Application Correspondence (both Y/31/21/PL & Y/32/21/A)

Subject: Barratt Temp Sales Office Applications (Y/31/21/PL & Y/32/21/A), Land at Drove lane, Yapton

Item 5 - quantity 1
Secondary sign medium (double sided)
Prefabricated folded aluminium panel
DIRECT DIGITAL PRINT
Complete with standard 2.5m posts
1000mm x 1285mm

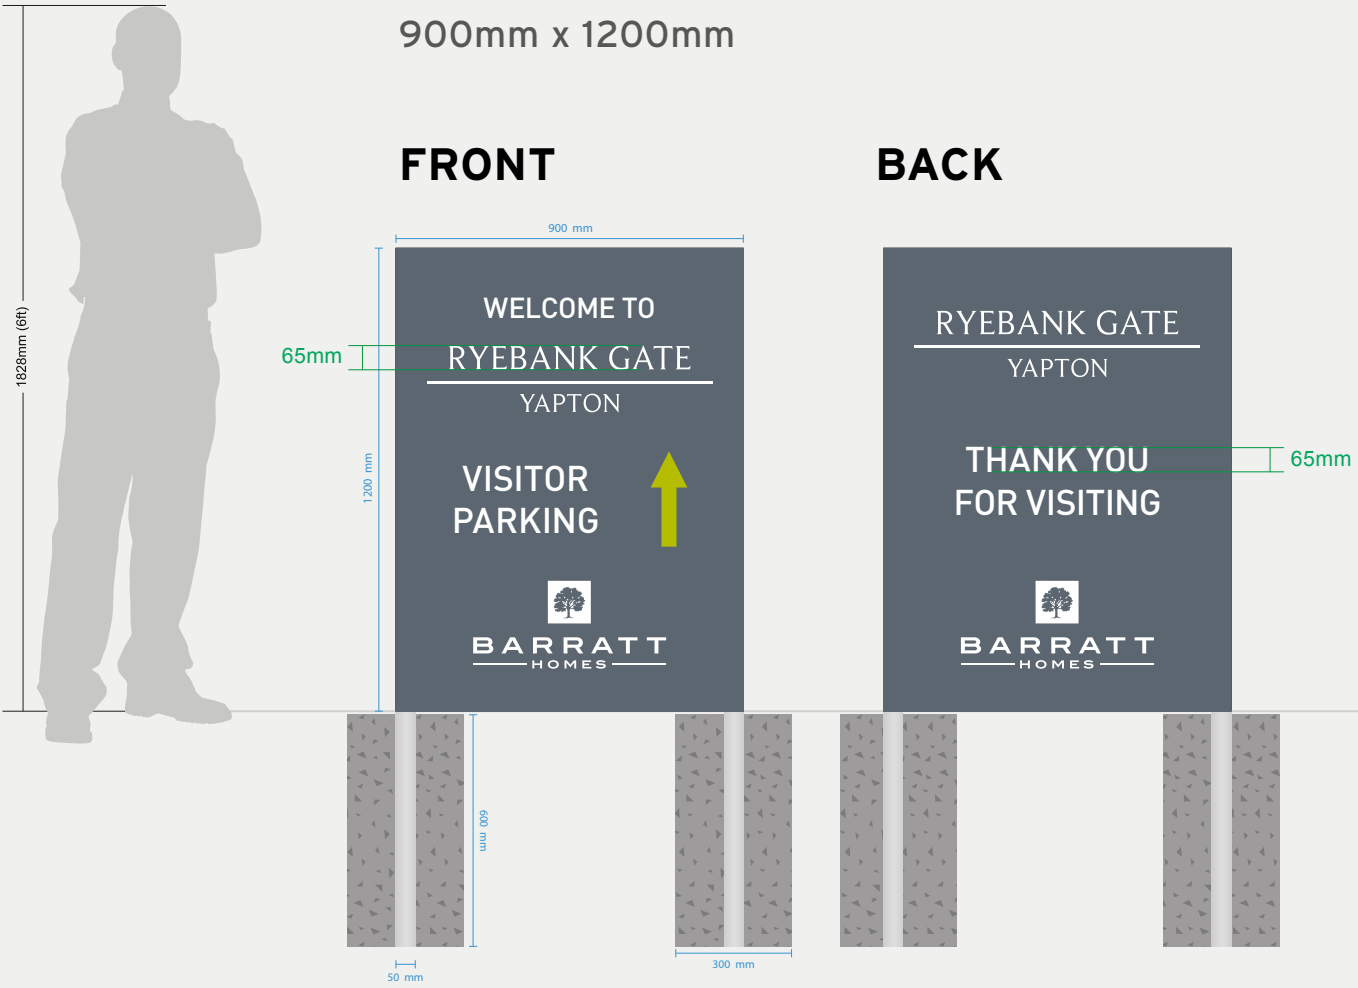
I write to alert you that it is our intention to refuse these two applications on the grounds of visual harm to the nearby heritage assets and to the character of the area/streetscene. You may also have noted on the application files the comments of our Conservation Officer and the Parish Council. I also consider that the amount of freestanding adverts/signs in the temporary area is excessive in such a sensitive location.

I acknowledge that the proposal is temporary (albeit it is unclear as to how long it would be in place for) but it is still likely to be in place for some period of time whilst the permanent sales area is built out. I note that the adverts are proposed for a 2 year period. In addition, this application does appear a little premature given that the previous refusal and that a resubmission has only recently been resubmitted – your application states the adverts are required from June this year?
